Recommendation Report for Planning Permission for Works or Extension to a Dwelling

REF NO: FG/55/22/HH

LOCATION: 4 Laburnum Close
Ferring
BN12 5EJ

PROPOSAL: Change existing external elevation materials to painted render.

DRAWING TITLE
EXISTING & PROPOSED ELEVATIONS

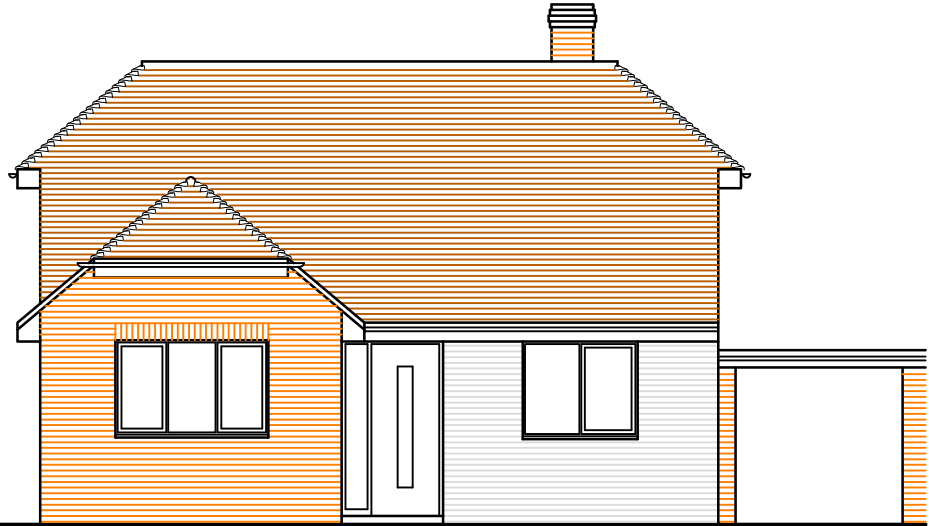
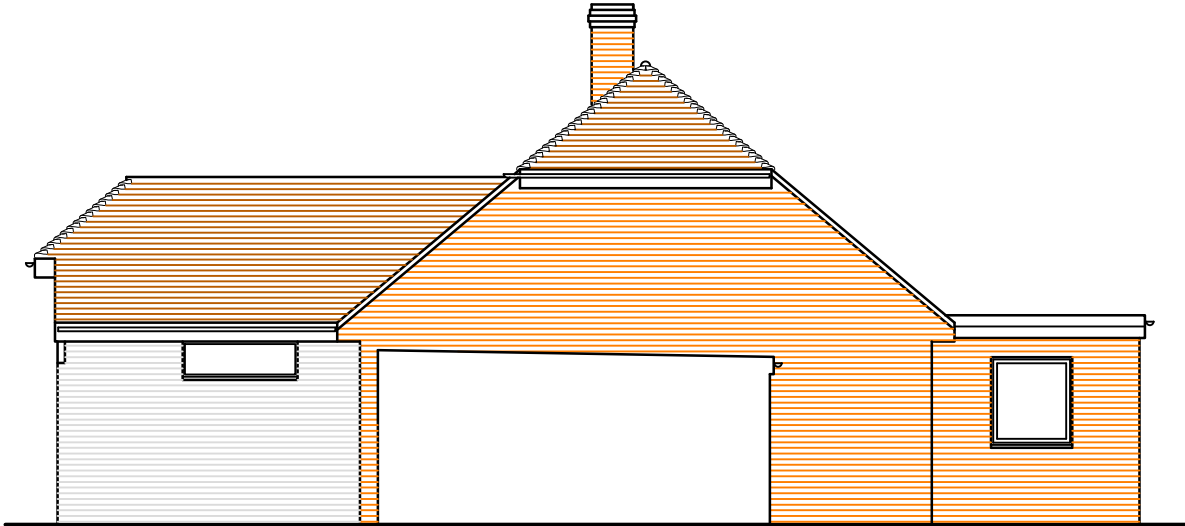
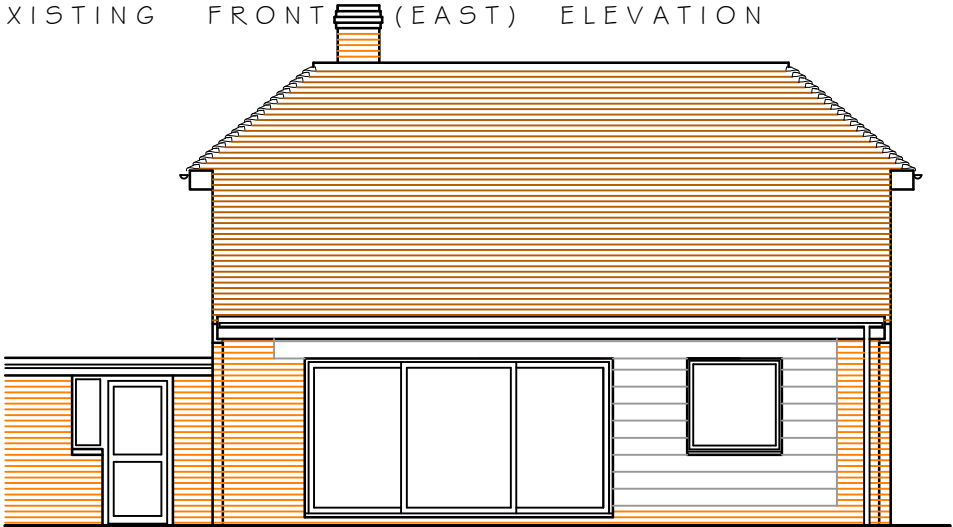
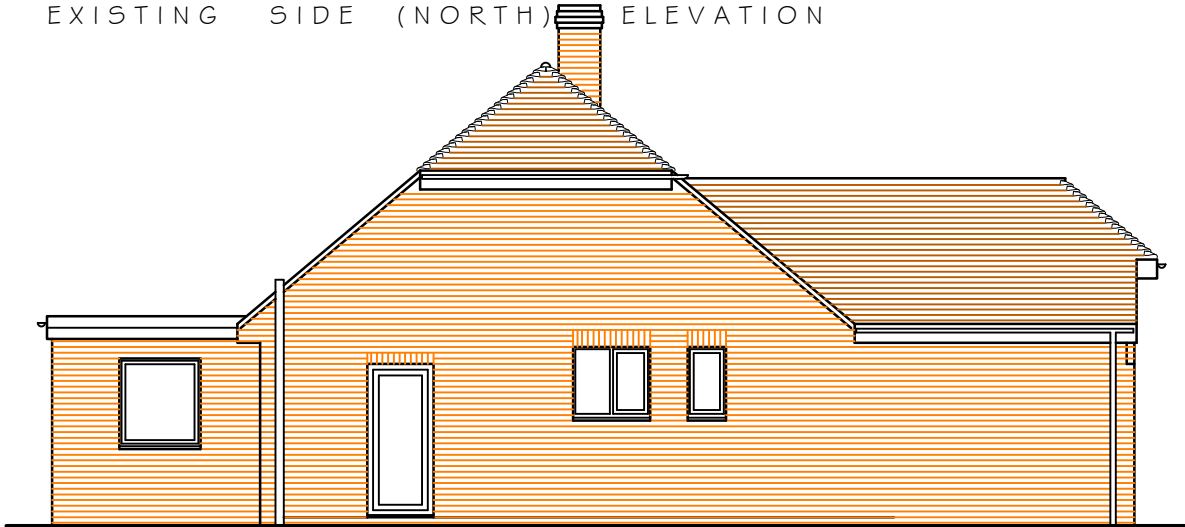
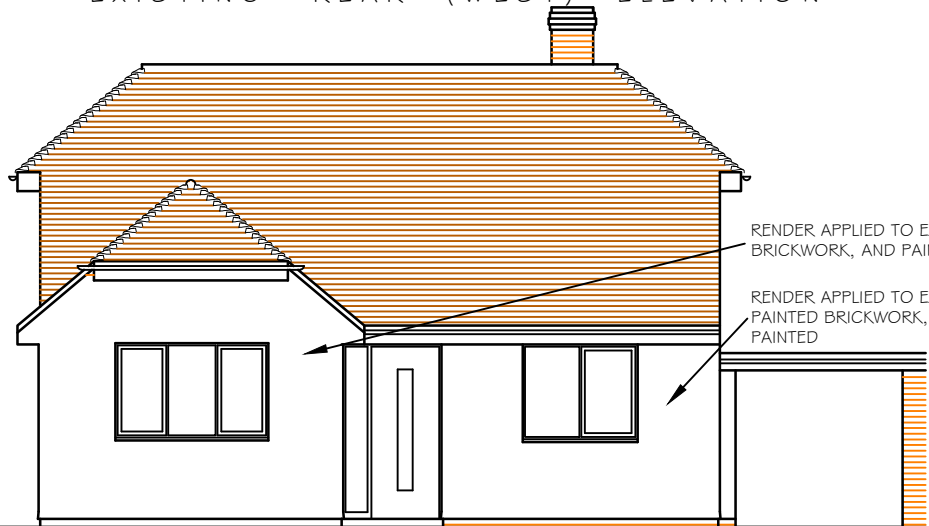
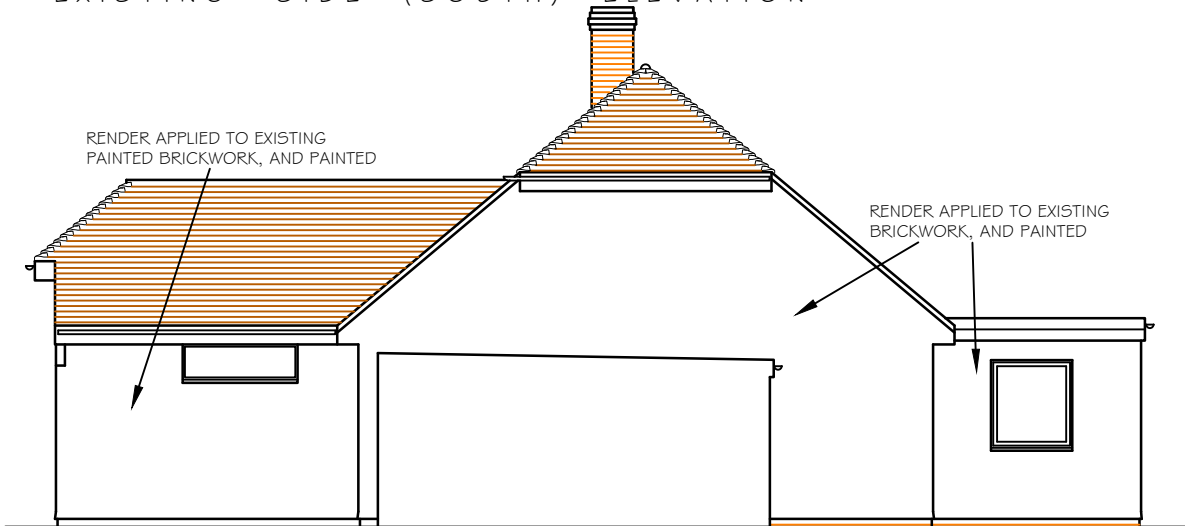
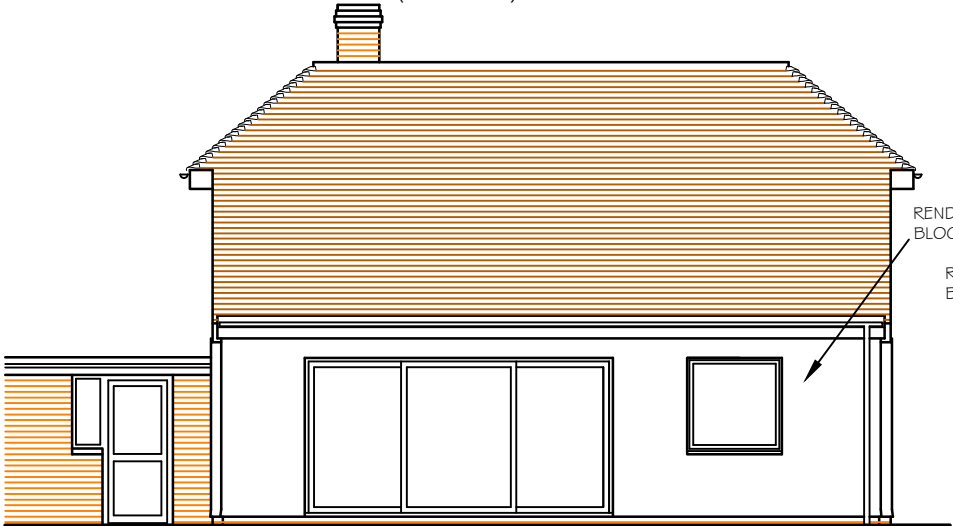
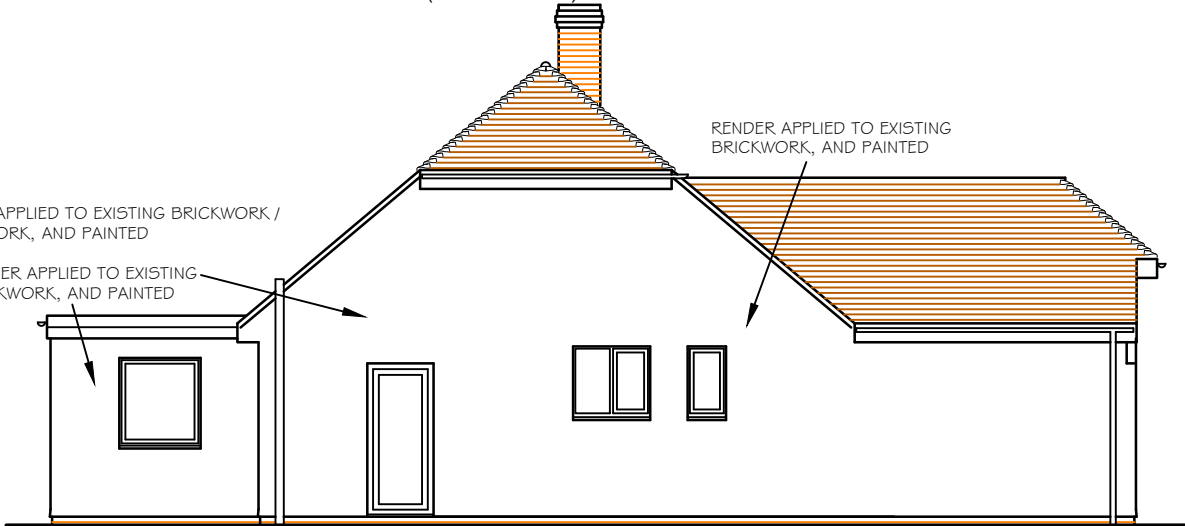
The works will be located on all elevations of the property and will be visible from the wider area.

As the proposal only requests external alterations to the property, the height and footprint of the existing structure will be retained. At present existing elevations are comprised of brickwork, painted brickwork, and blockwork. The proposal seeks to render and paint all elevations, so all walls are uniform. This will alter the appearance of the property. Being on all elevations, the works will be visible from the street scene. The property is set back slightly from the street the impact of the proposal will not be unduly harmful to the composition or appearance of the area. Most neighbouring properties exhibit brickwork elevations, of which No.4 would then differ. This difference would be notable in the context of the street but would add a smart, contemporary appearance to the dwelling. The contrast with its neighbours through the addition of render would not cause demonstrable harm to the character of the area or of the property itself.

Although able to be viewed from the street scene, the works proposed are not harmful to the local character of the area and have minimal impact upon visual amenity. This is in accord with D DM1 and D DM4 of the Arun Local Plan, the Neighbourhood Plan, and Arun Design Guide.
